APPLICATION NUMBER 3/2012/0099
MOOR HOUSE FARM, CLITHEROE ROAD, KNOWLE GREEN

A planning application has been submitted by Mr Allan Lloyd-Haydock of A.L.H. Design Services on behalf of Mr Roy Brown for the erection of an agricultural building. A site visit was whilst the applicant was present and the information provided at this meeting, together with the written submissions, forms the basis of this appraisal.

It is proposed to erect a building as shown on drawing number 110B. The building would be divided into three main uses: a livestock housing area and wood store; two stables and a tack room; and a machinery/hay store with workshop.

0382 / 93 Drawing No 110 B

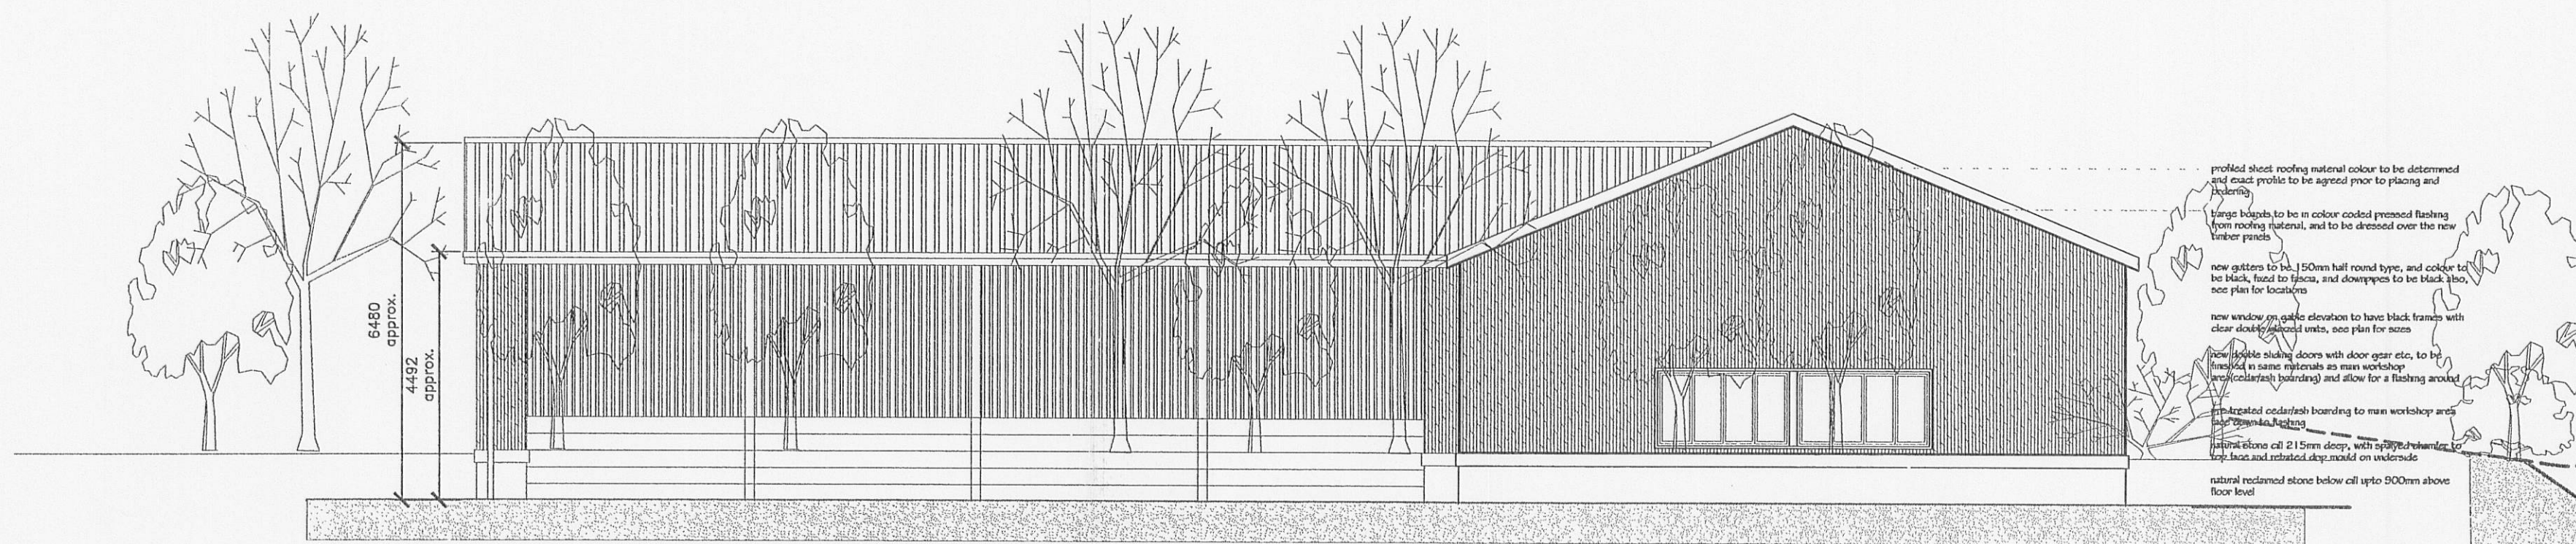
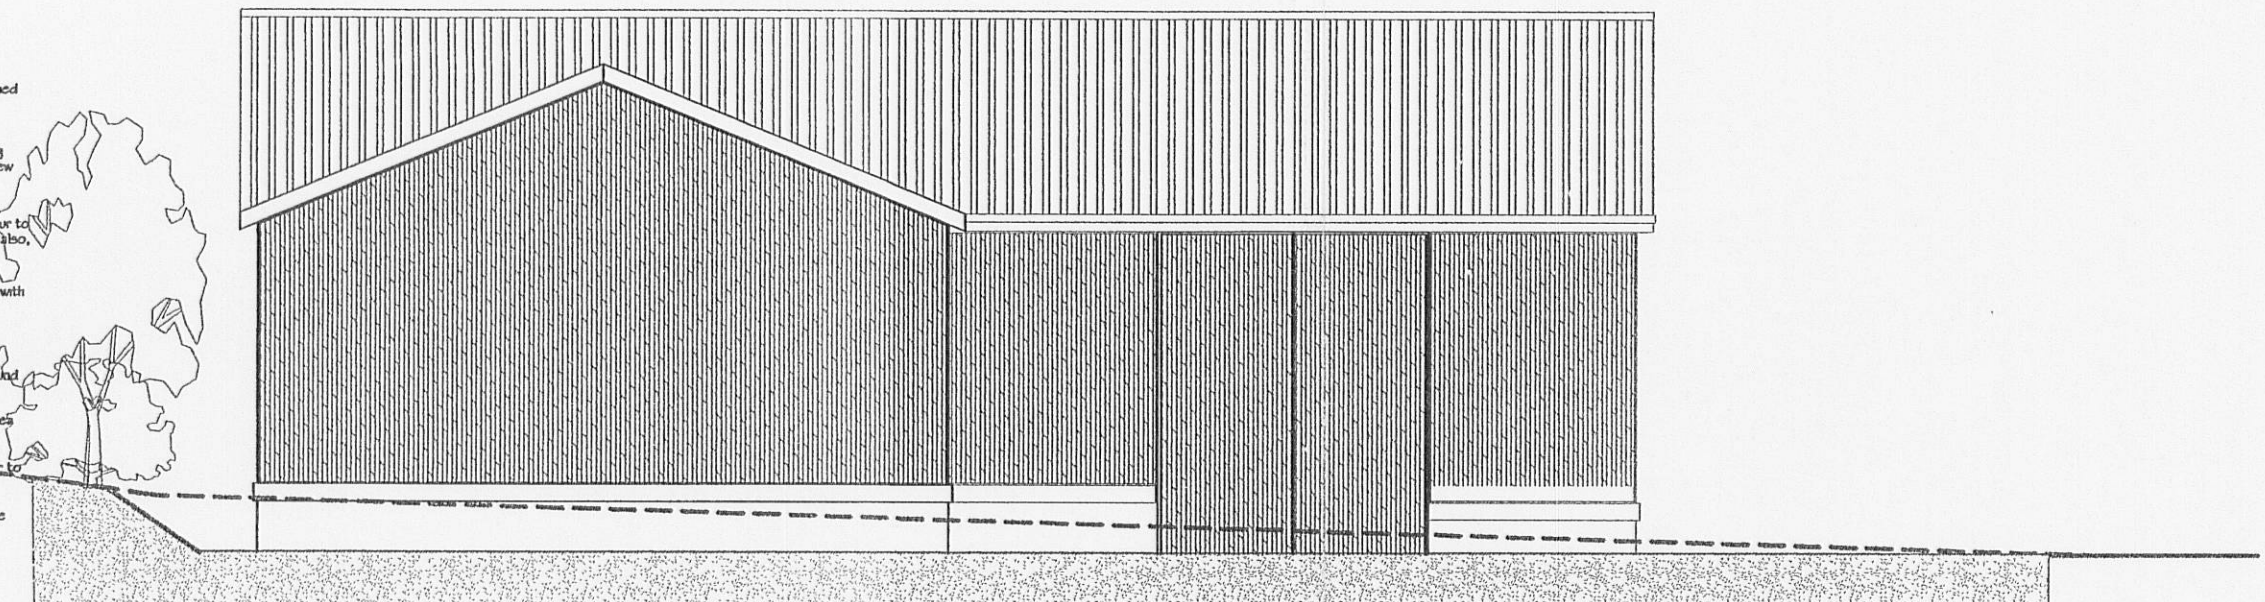
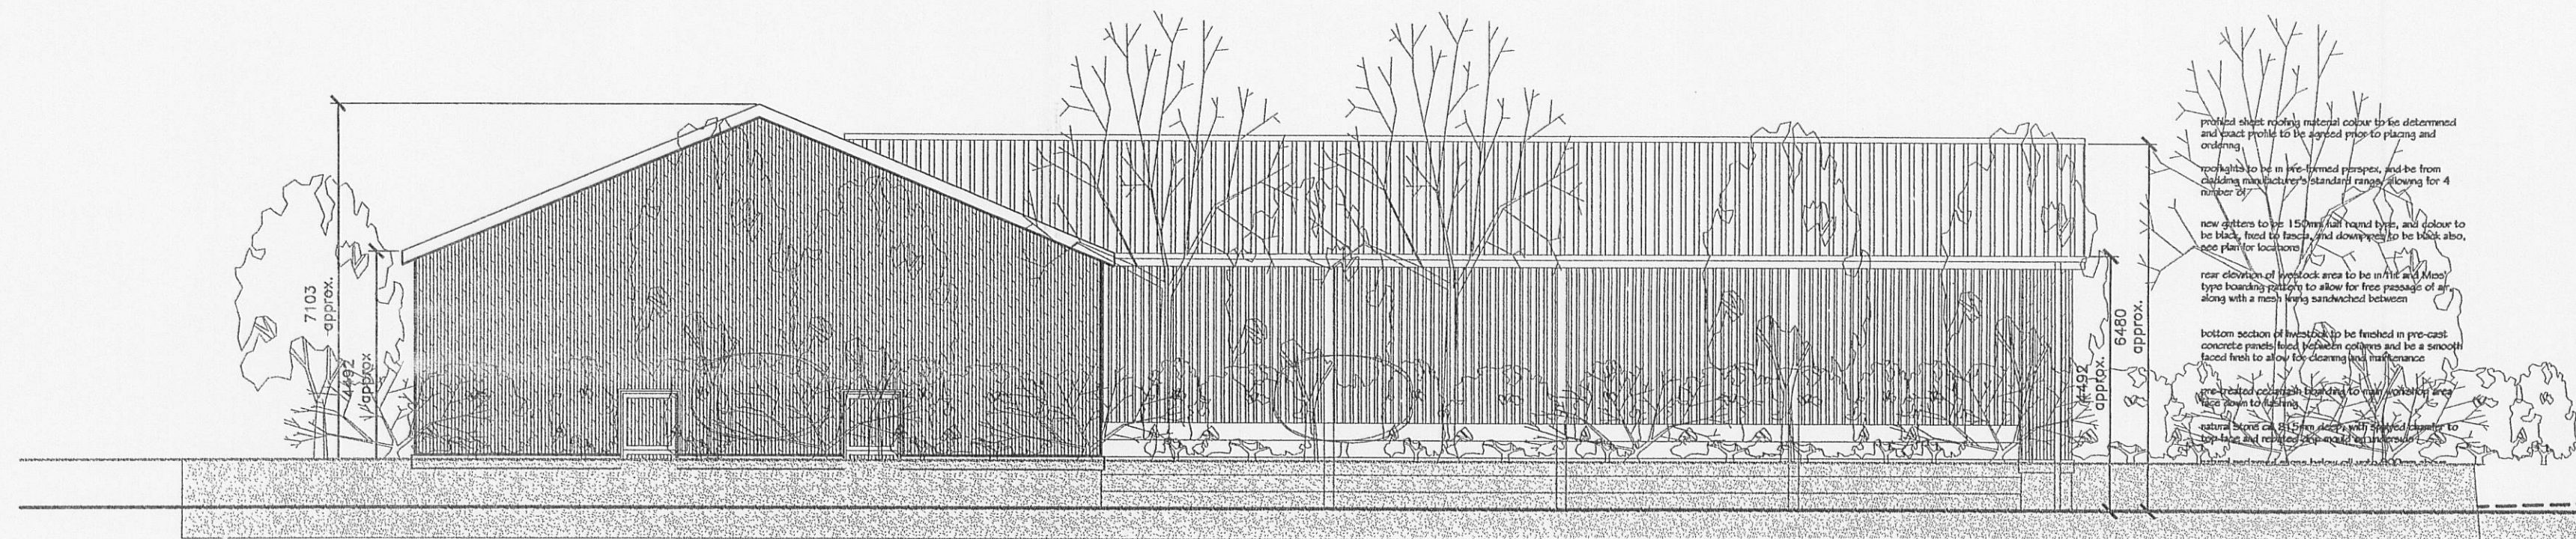
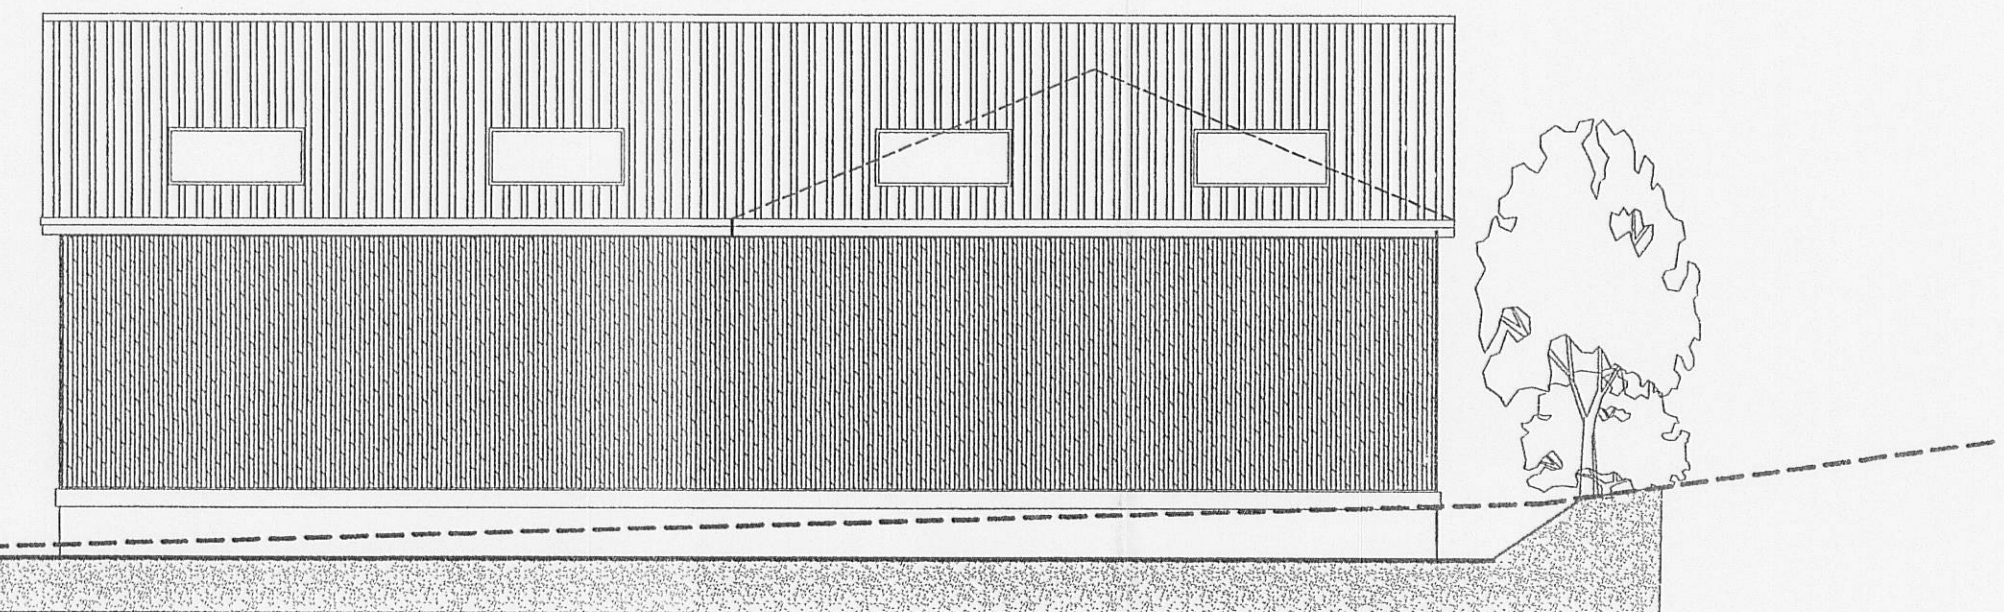
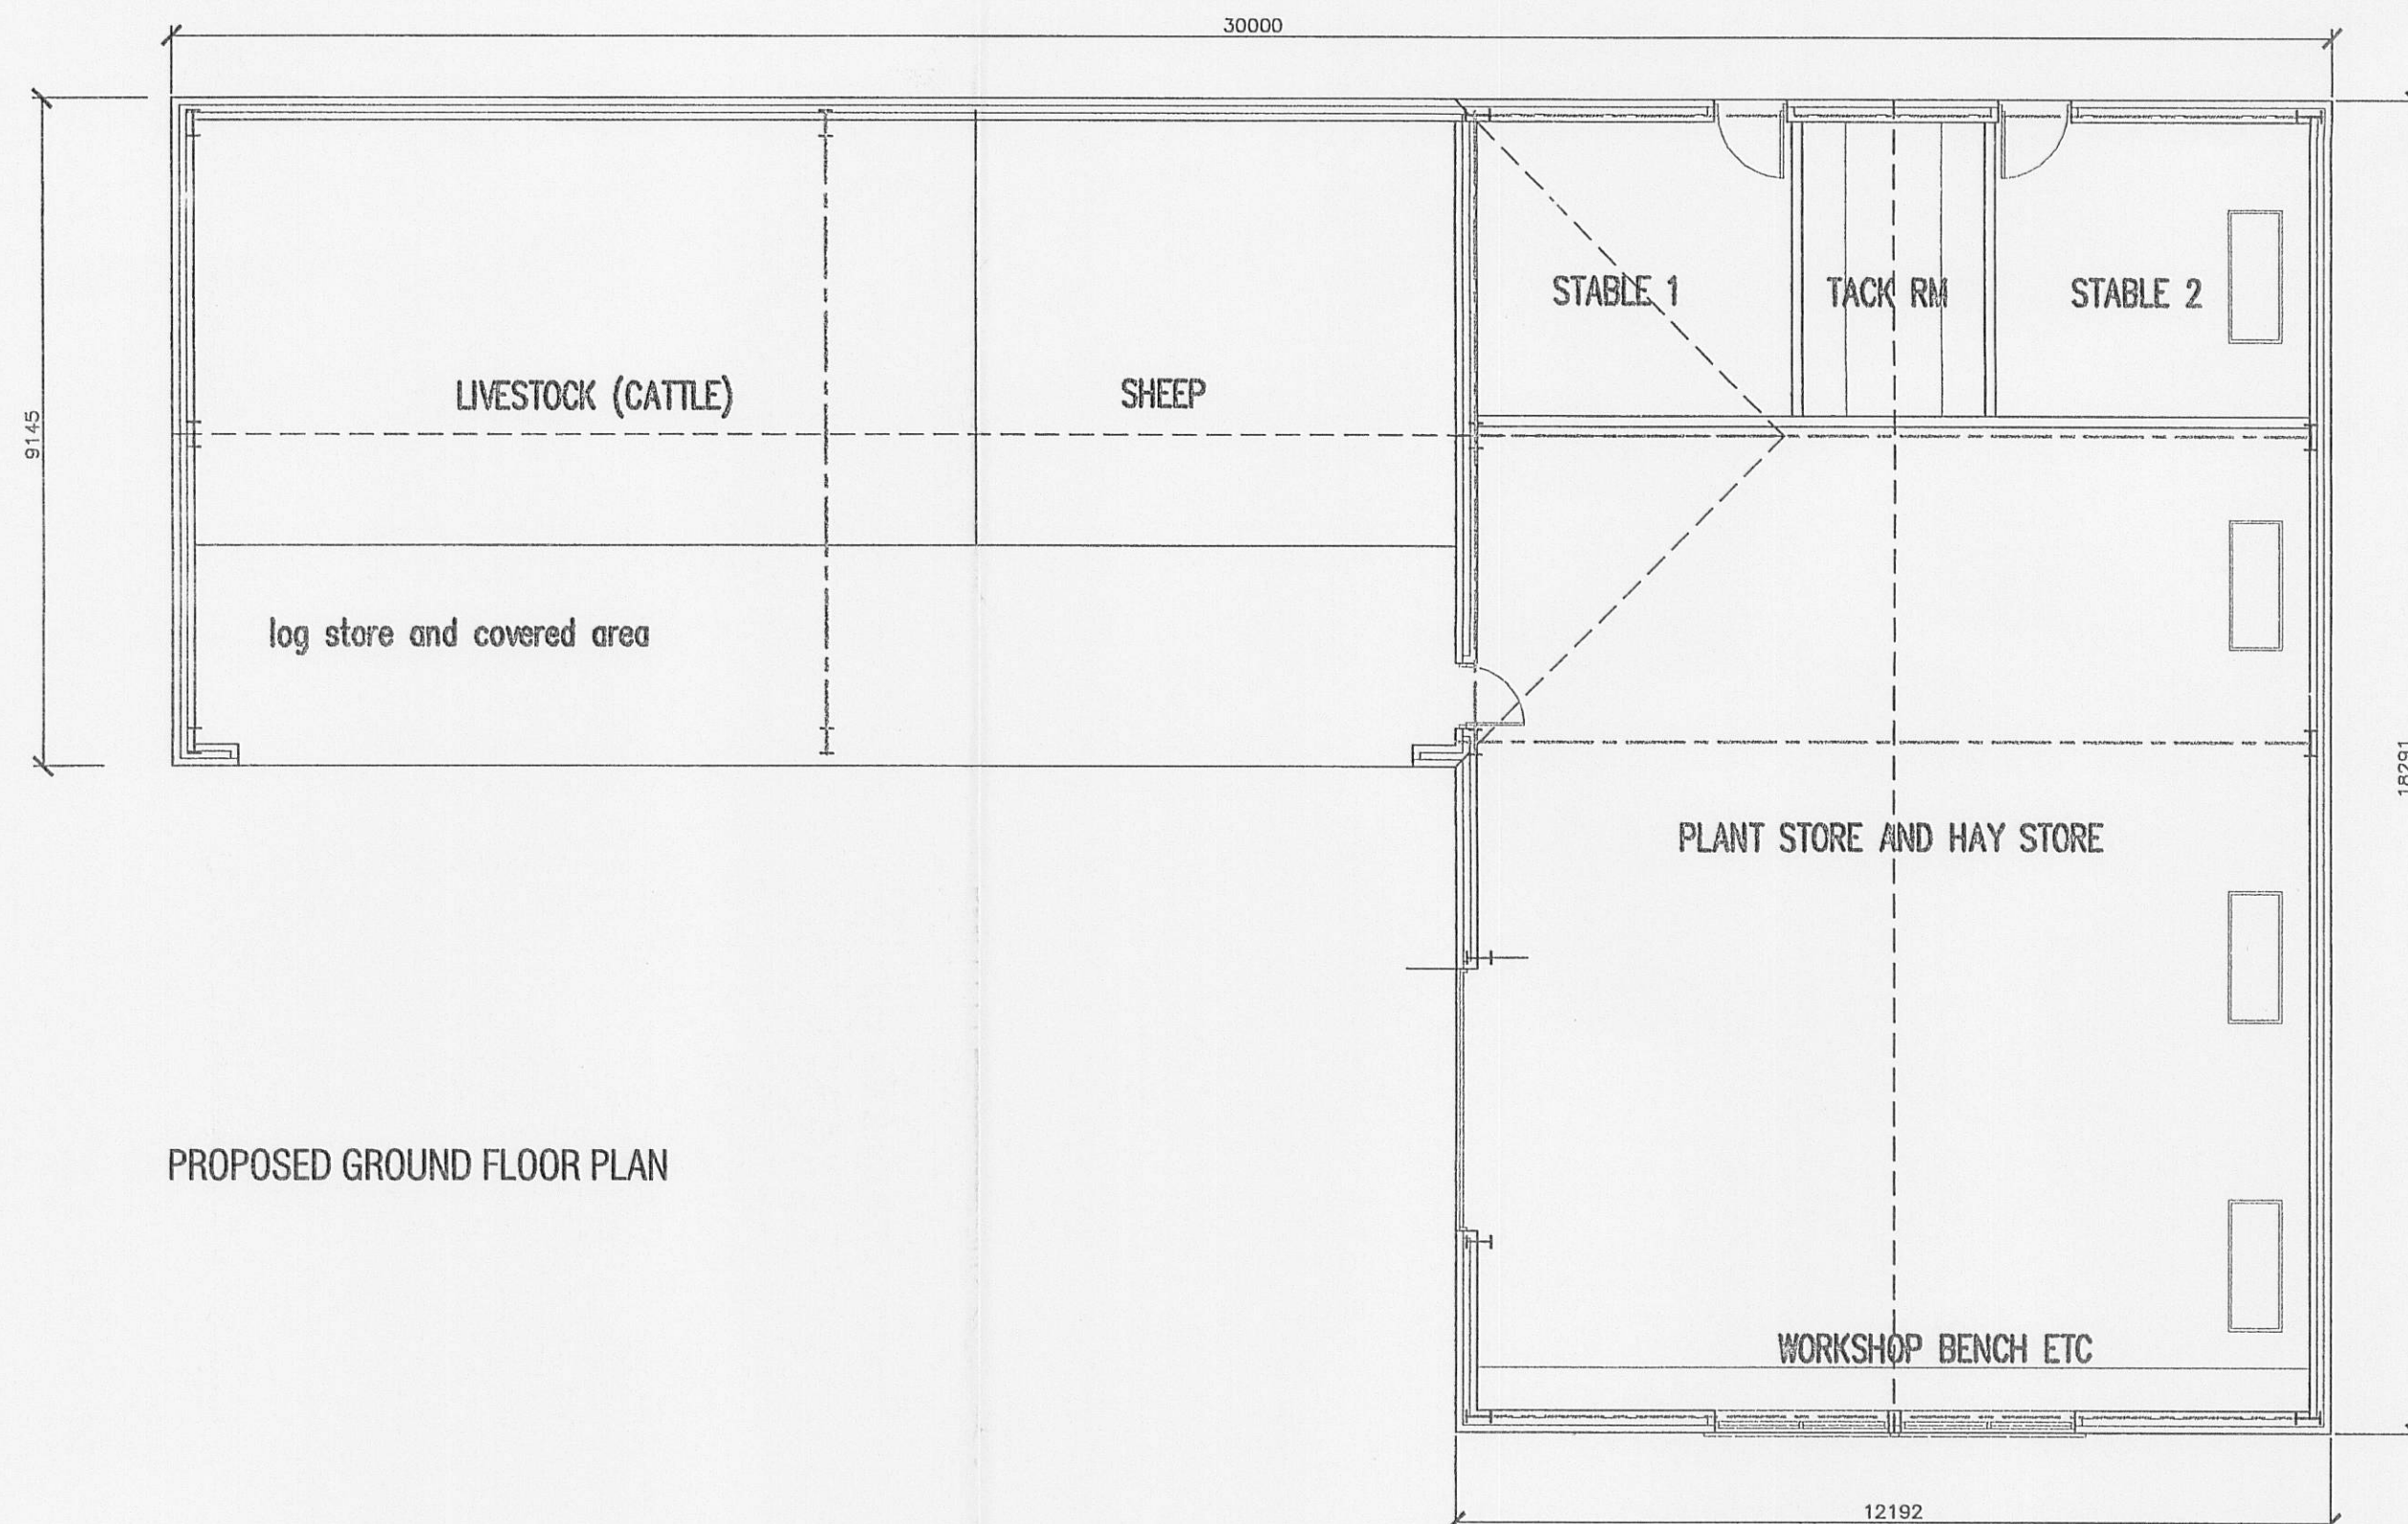
The scale of the proposed building is in my mind more akin to a facility that would be found on a larger unit e.g. high eaves height and the proposal for a workshop area. Also the proposed building does not appear to take into account the opportunity for dual uses and it should also be noted that the existing stone barn does provide some storage space. The general appearance/design of the proposed building is also not typical of an agricultural building i.e. concrete walling with Yorkshire boarding above with ease of access.

The proposed site of the building is some distance from the existing barn and house. Whilst the proposed site could be used, other sites closer to the existing buildings may also be suitable.
